| Our Ref: | NE/22/00422/FUL |
| Date: | 7 April 2022 |

Proposal: Single storey front extension (re-submission of NE/21/00666/FUL) at 1 The Drift Collyweston Stamford PE9 3PH.

Drawing  
**PLANS AND ELEVATIONS AS EXISTING**

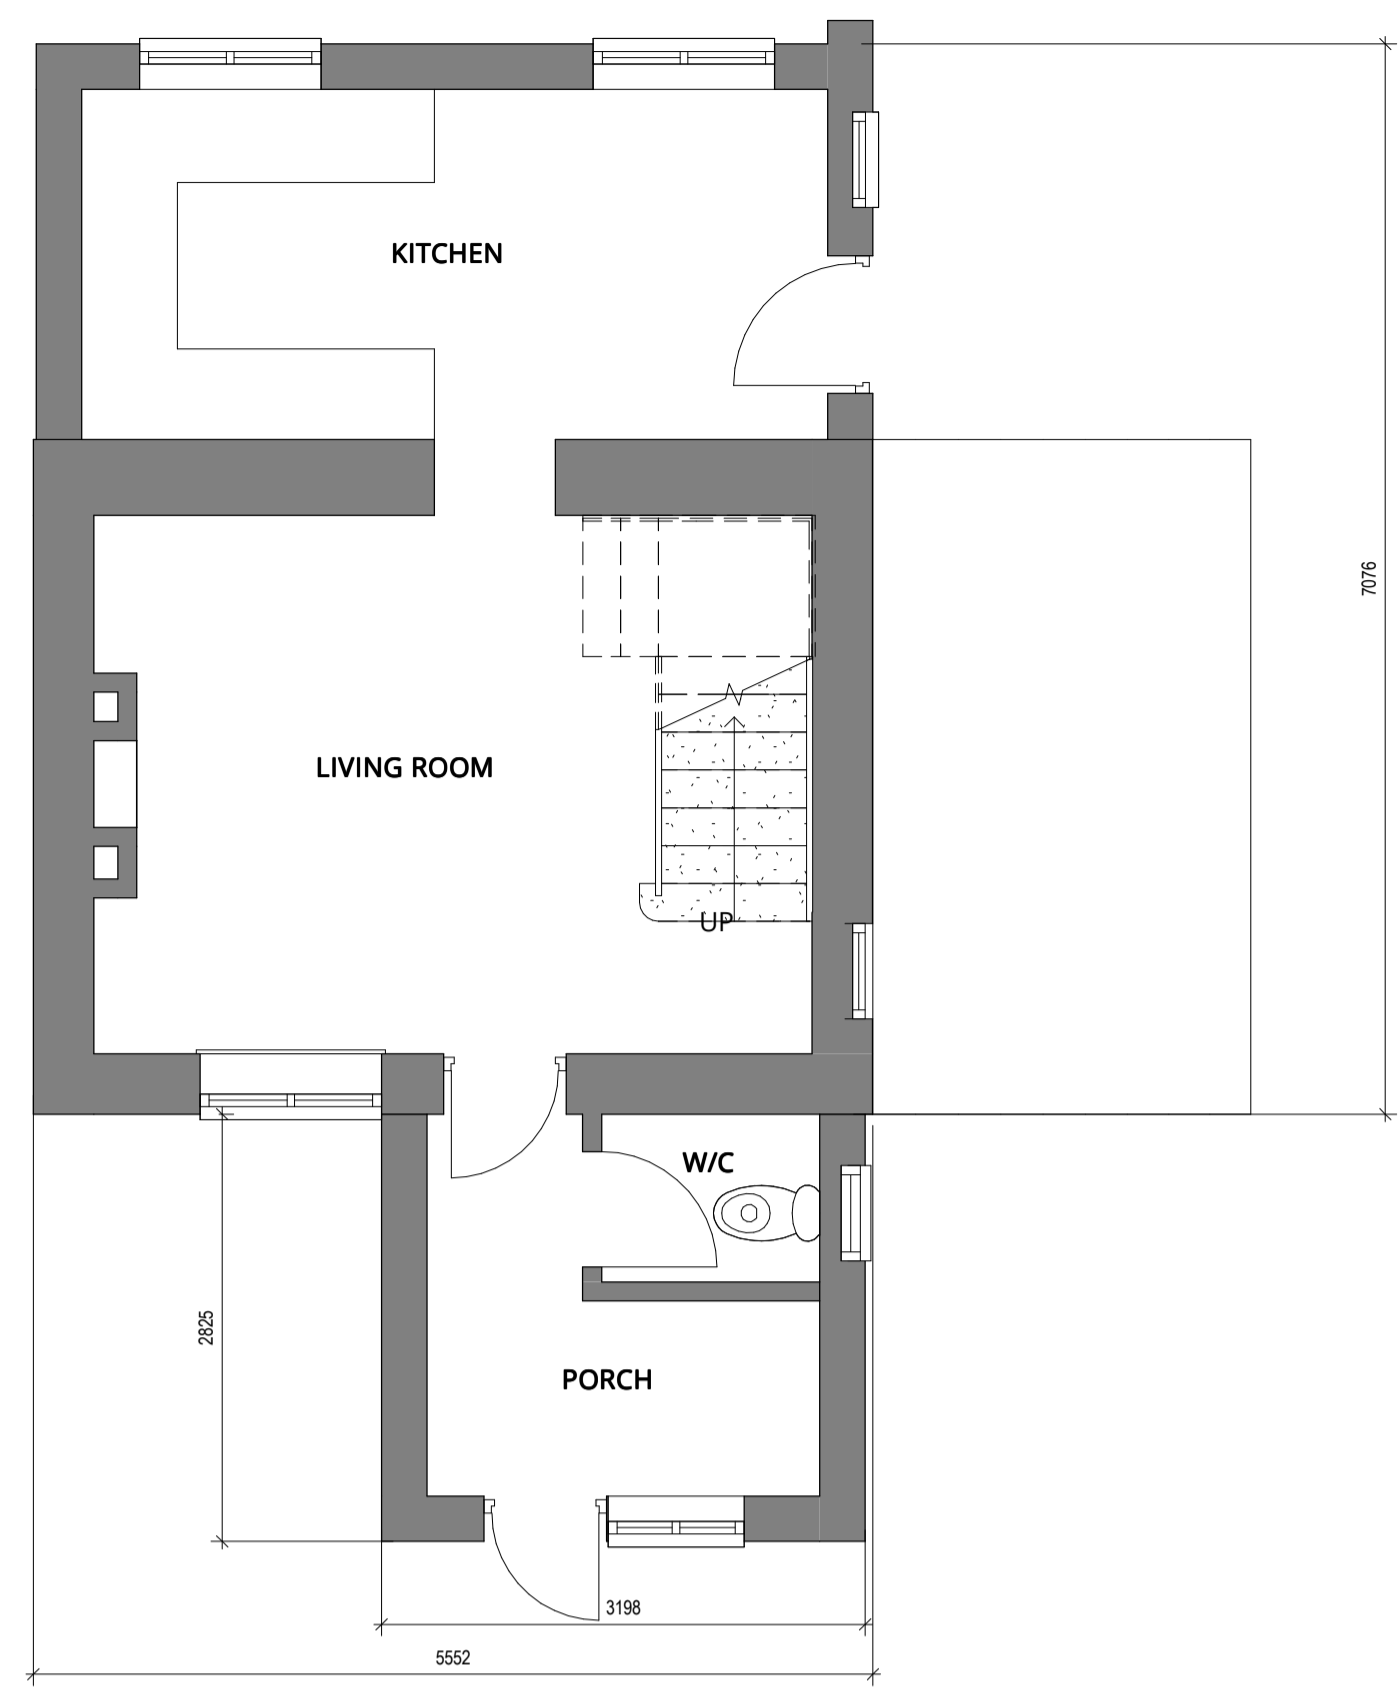
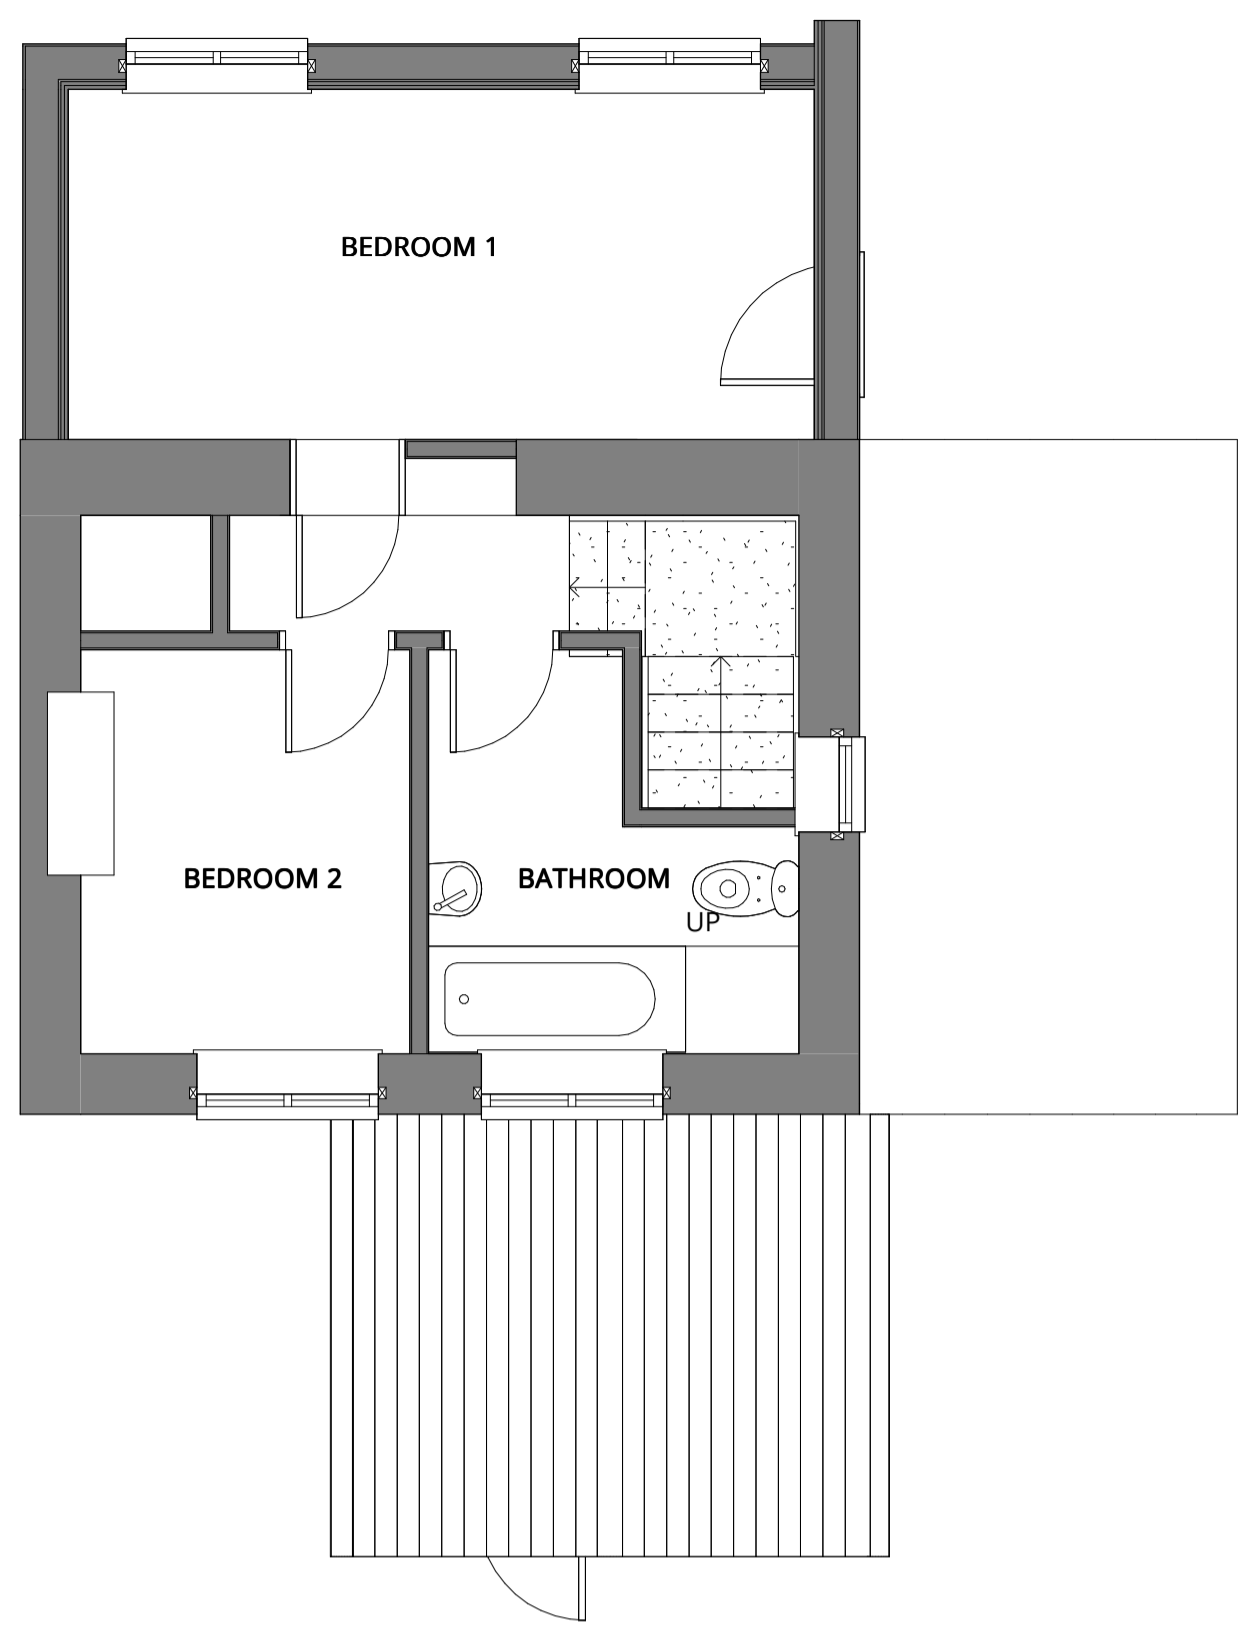
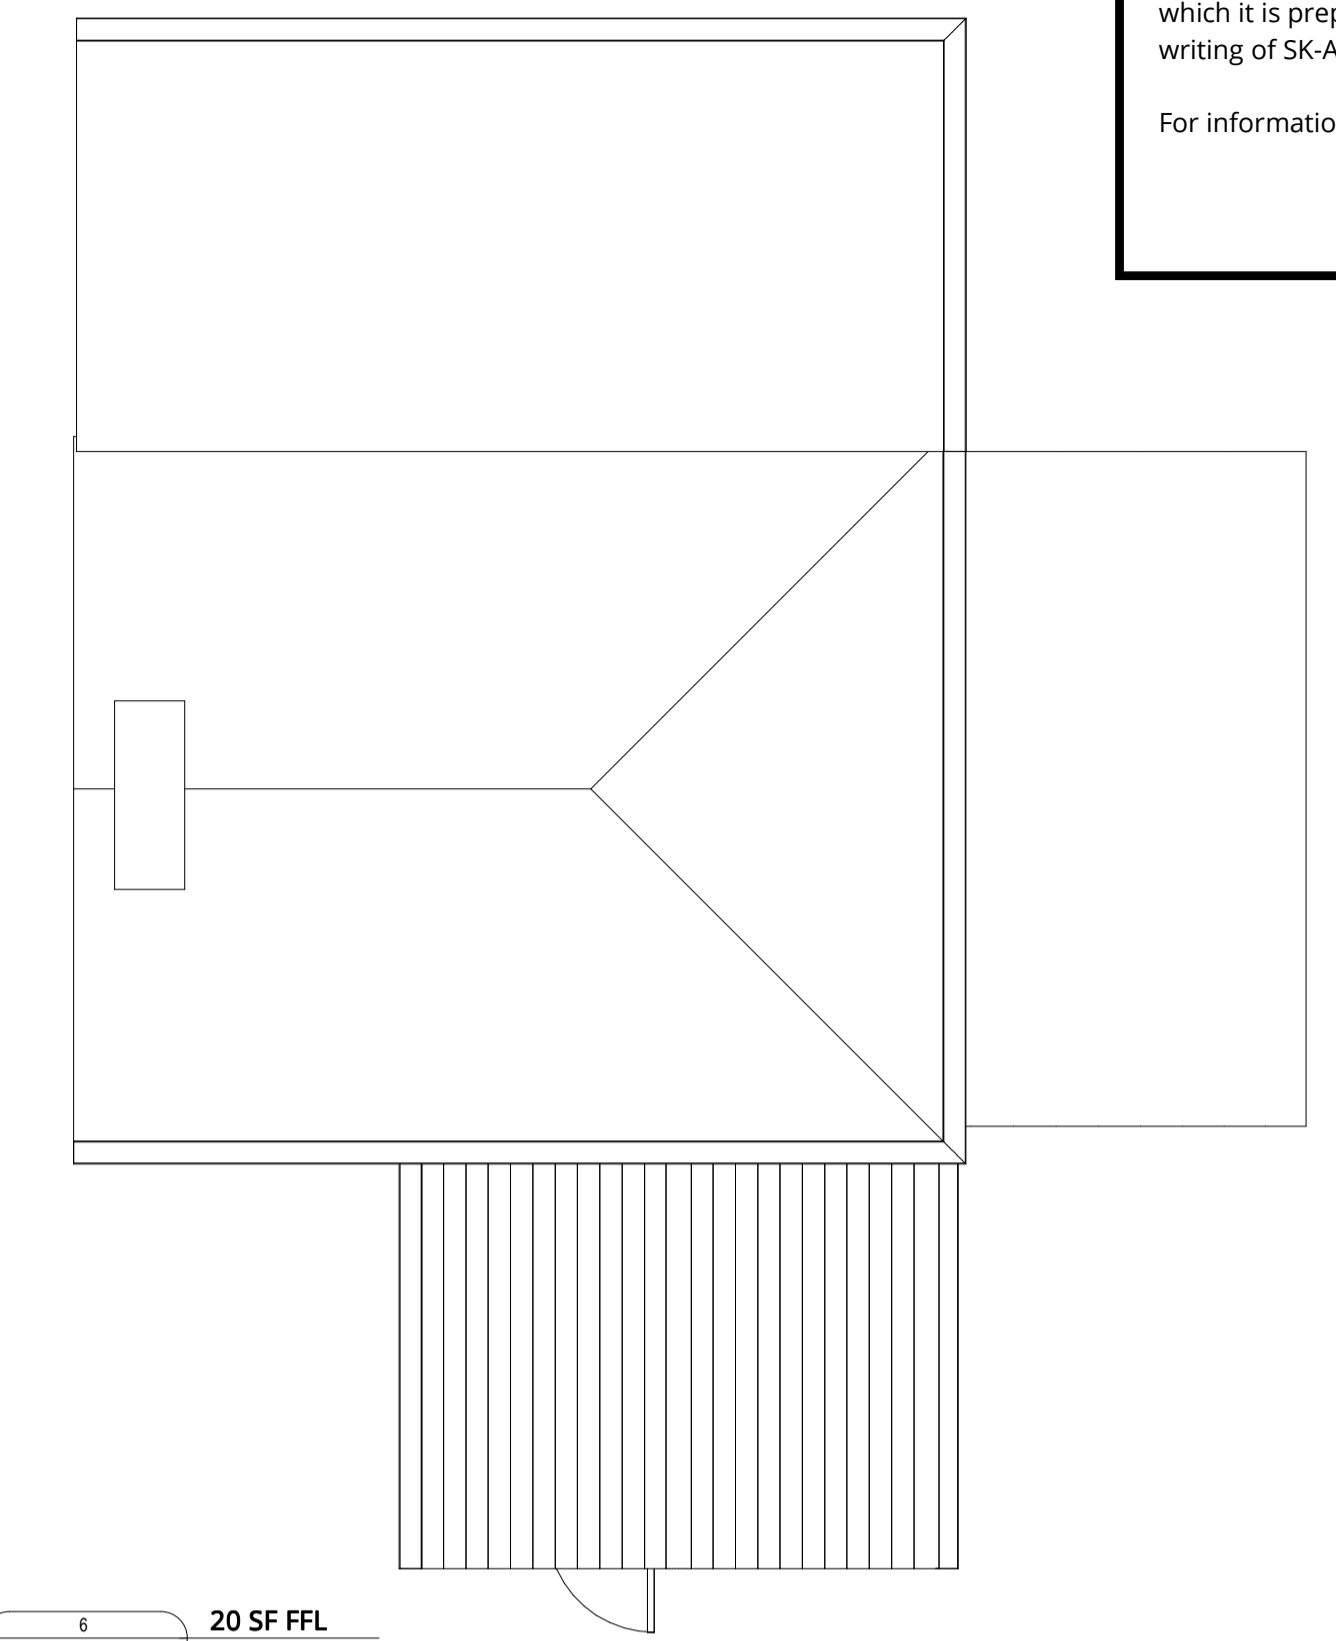
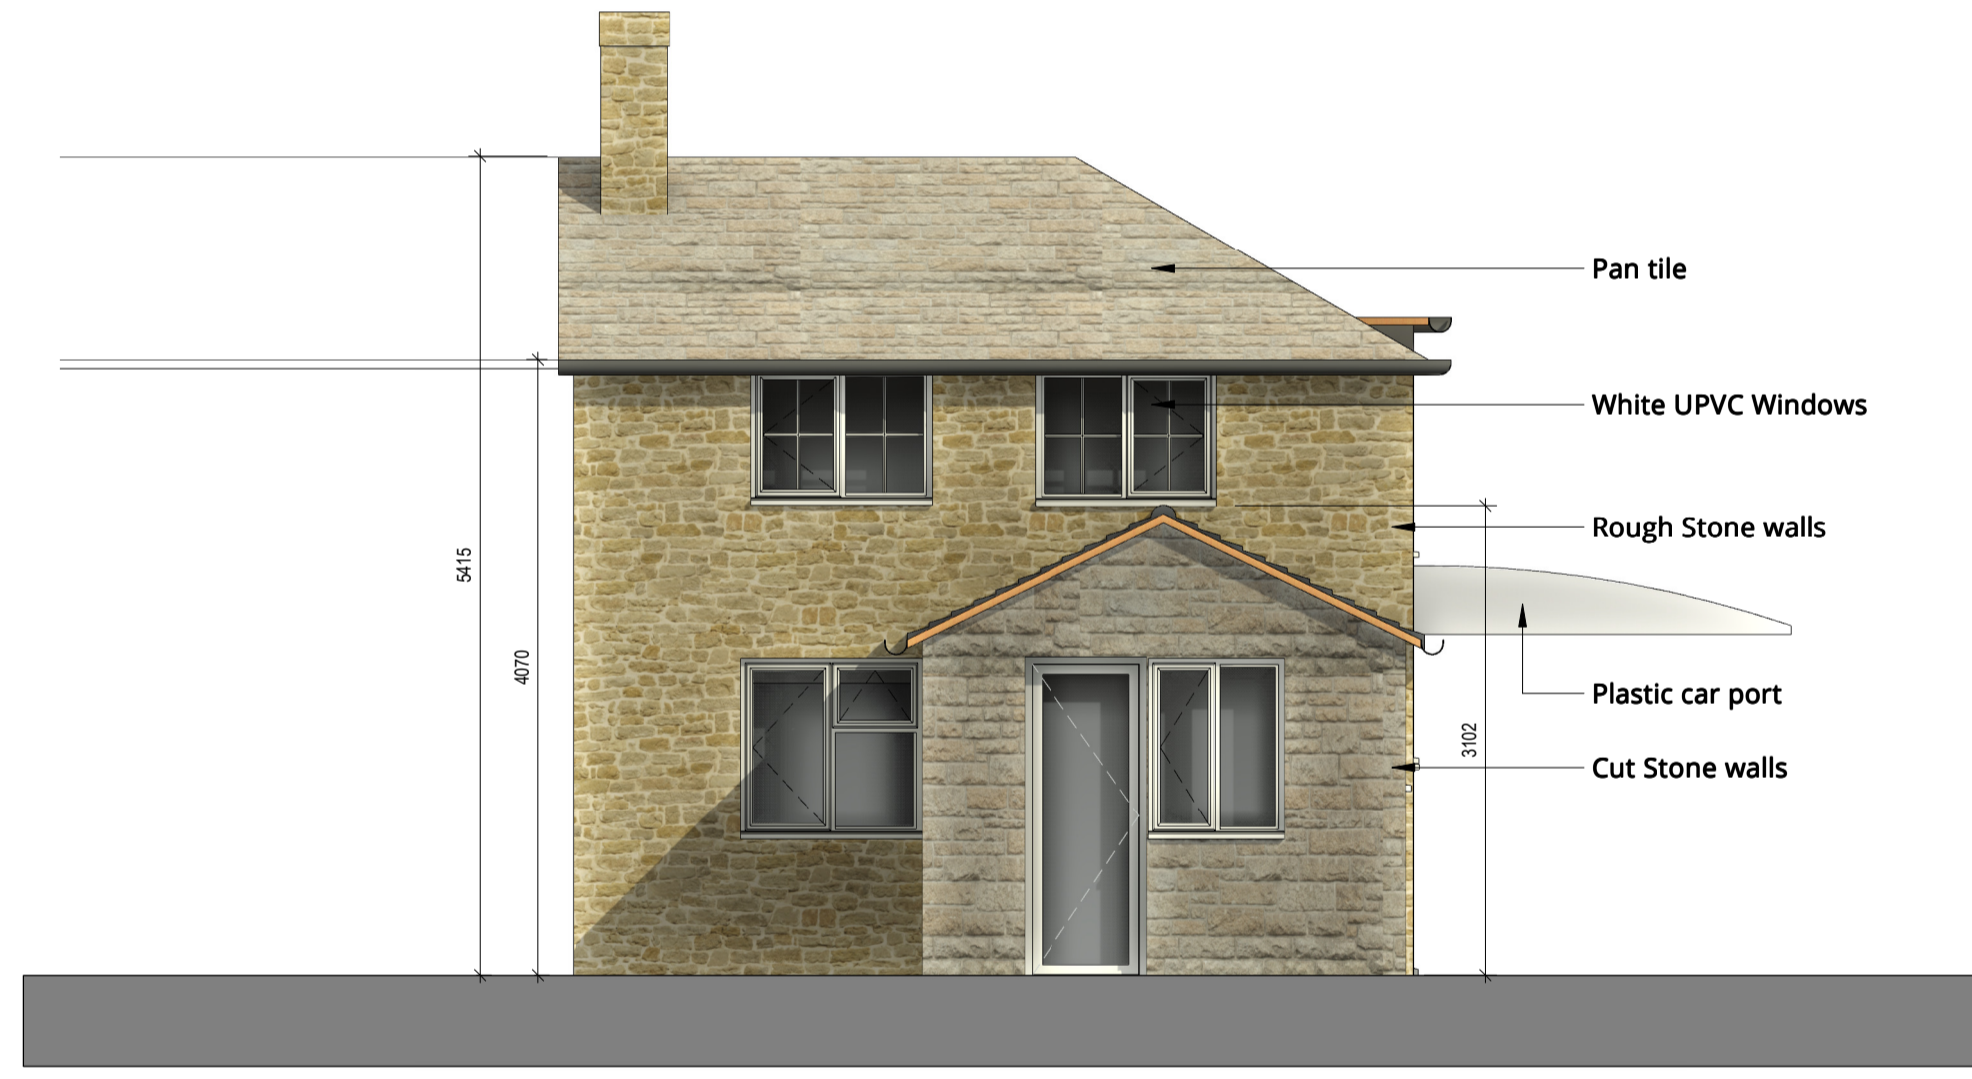
1. Thank you for the drawings submitted with your application, even though the scale used has been given all the relevant dimensions have not been provided. As per our published Local Requirements, "All plans and drawings must be drawn to an appropriate metric scale (1:50 or 1:100) and have all relevant dimensions of the key elements of the proposal clearly written. This includes the height, length, width and (if relevant) the distance from the site boundary of any proposed works. We require this so that the proposed dimensions are clear when plans are viewed online." This is required as we now run a completely paperless planning office.

Please provide amended drawings including all relevant dimensions of the proposal:

- Dimensions for the existing and proposed floor plan
- Dimensions for the existing and proposed elevations annotated with all height dimensions

Therefore, please give your written authorisation for this statement to be removed from the drawings or to be altered to read "For planning purposes only". On amended drawings, submitted please remove or alter this statement.
